Ref BR/82/22/PL

RE Plans for the demolition of the existing buildings and the building of 10 flats/dwellings rear of Holmlea, Town cross avenue PO21 2DN

Proposed Apartments
Planning

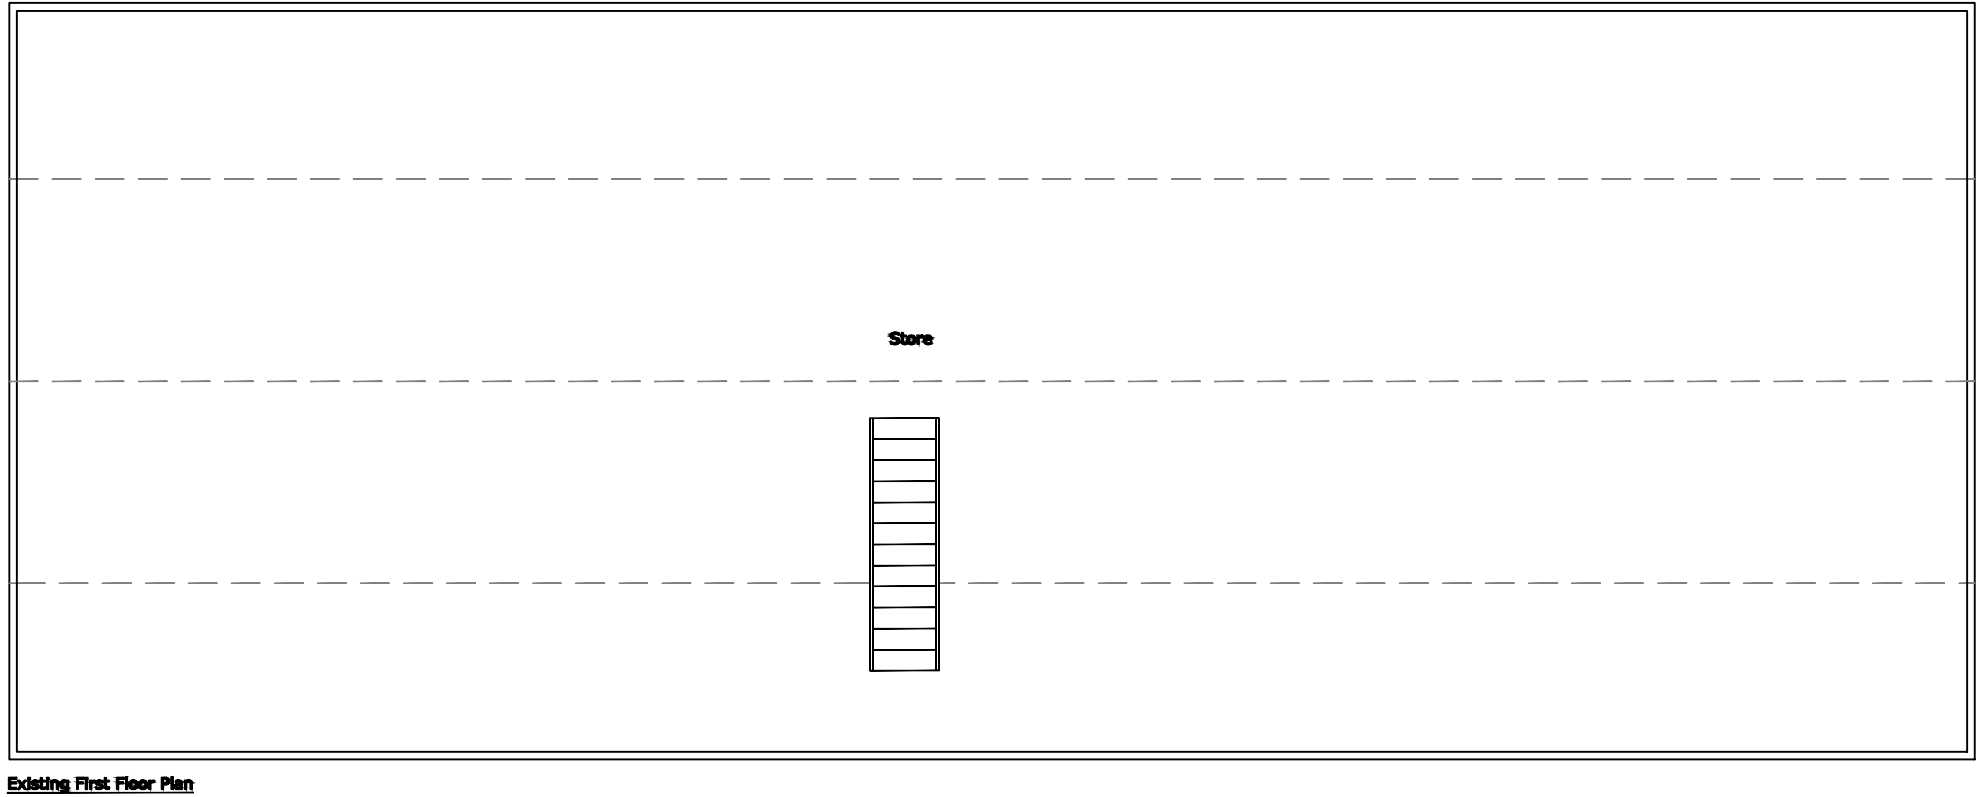
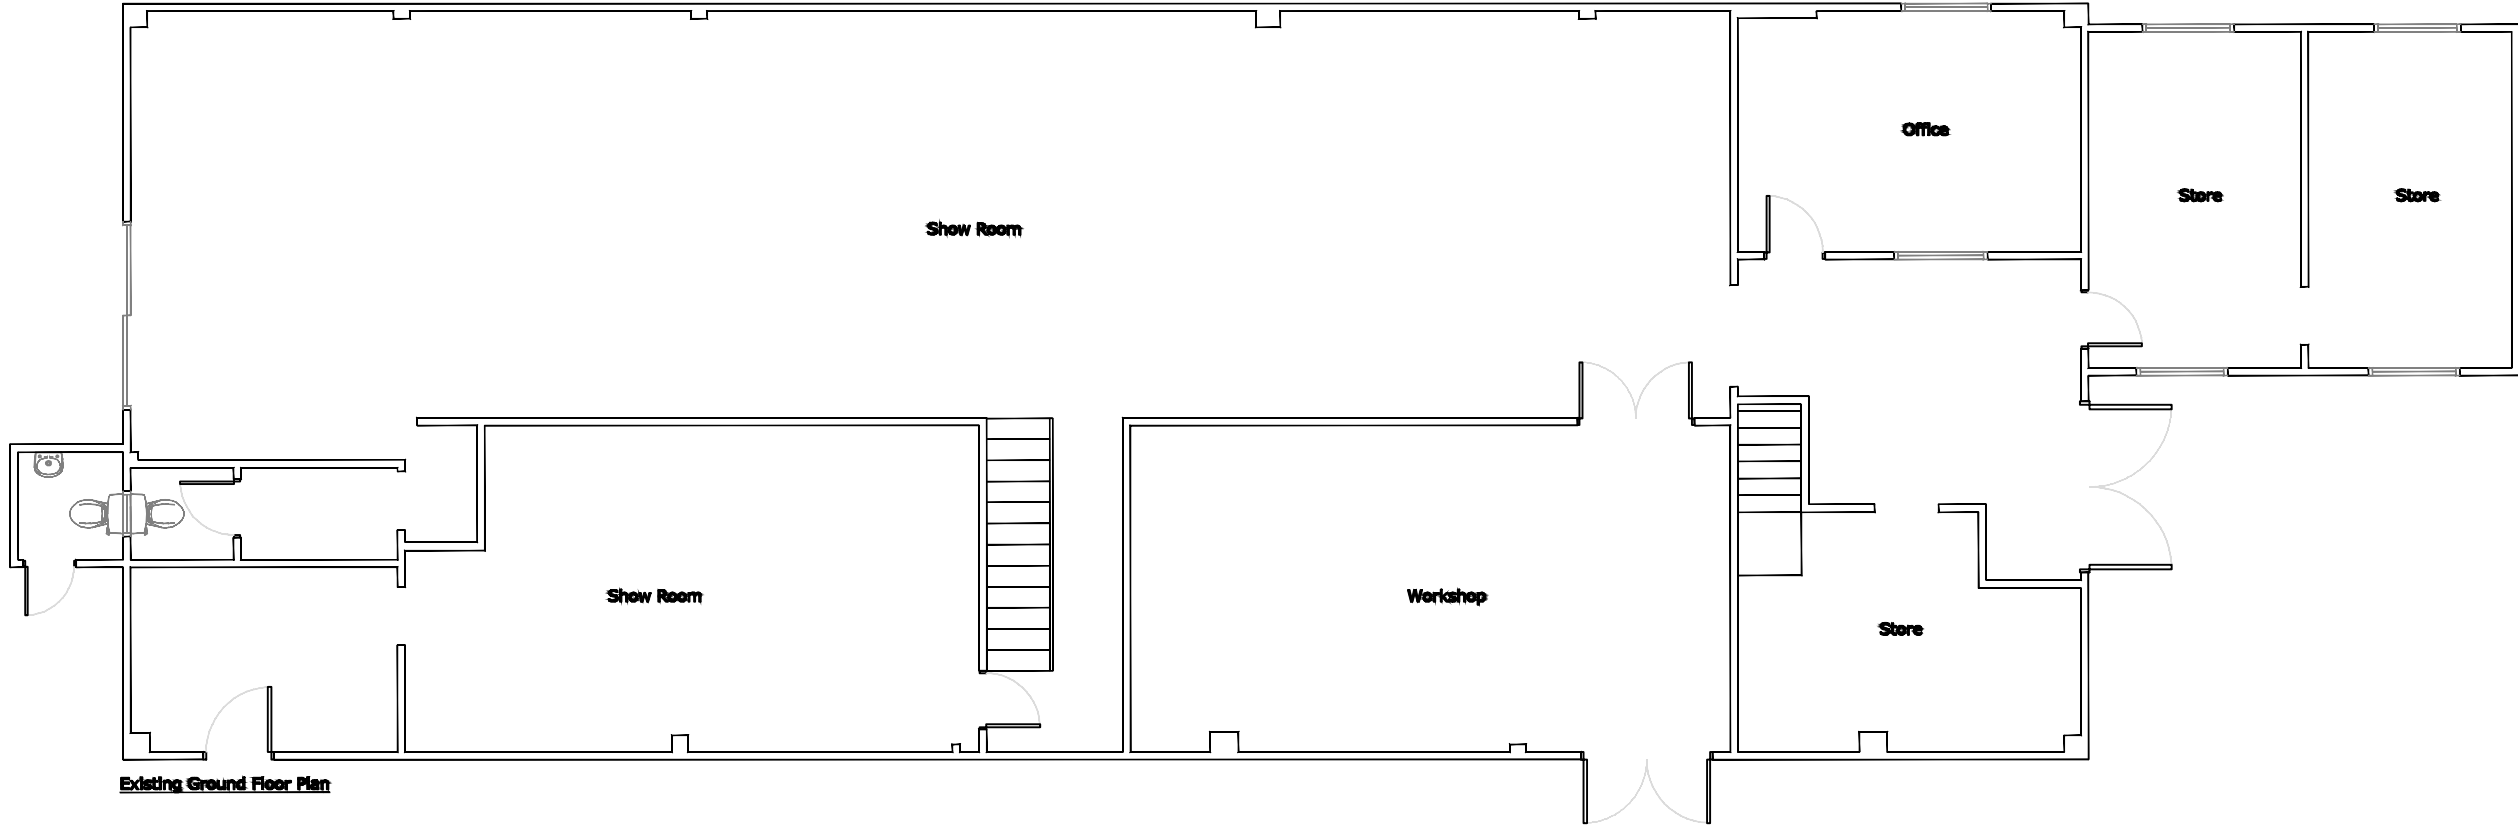
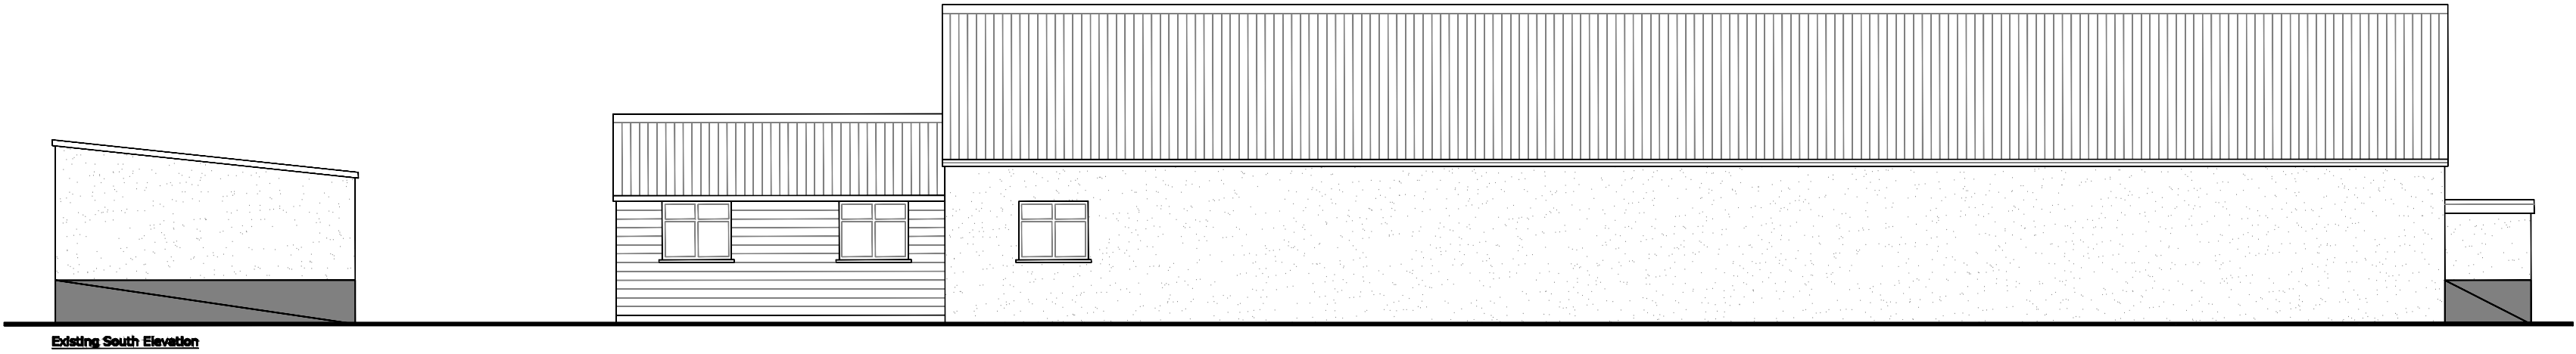
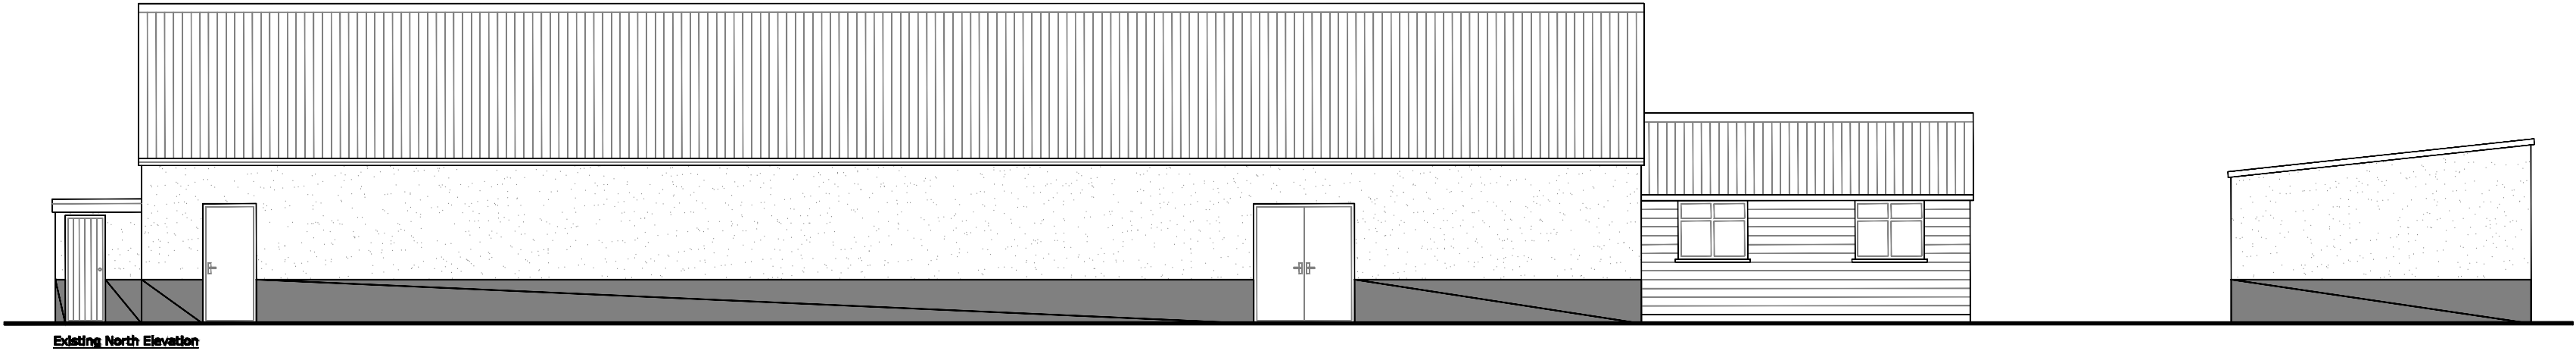
The middle section of the proposed building is very high, currently the buildings are only one storey high, a two storey building would decrease natural light into all our homes in its vicinity at Town cross Avenue, Halson close and Essex road.

The plans show that the back of mine and my neighbours garden's would become a car park, are plans in place to protect me and my neighbours fencing/property from car damage, such as a crash barrier?
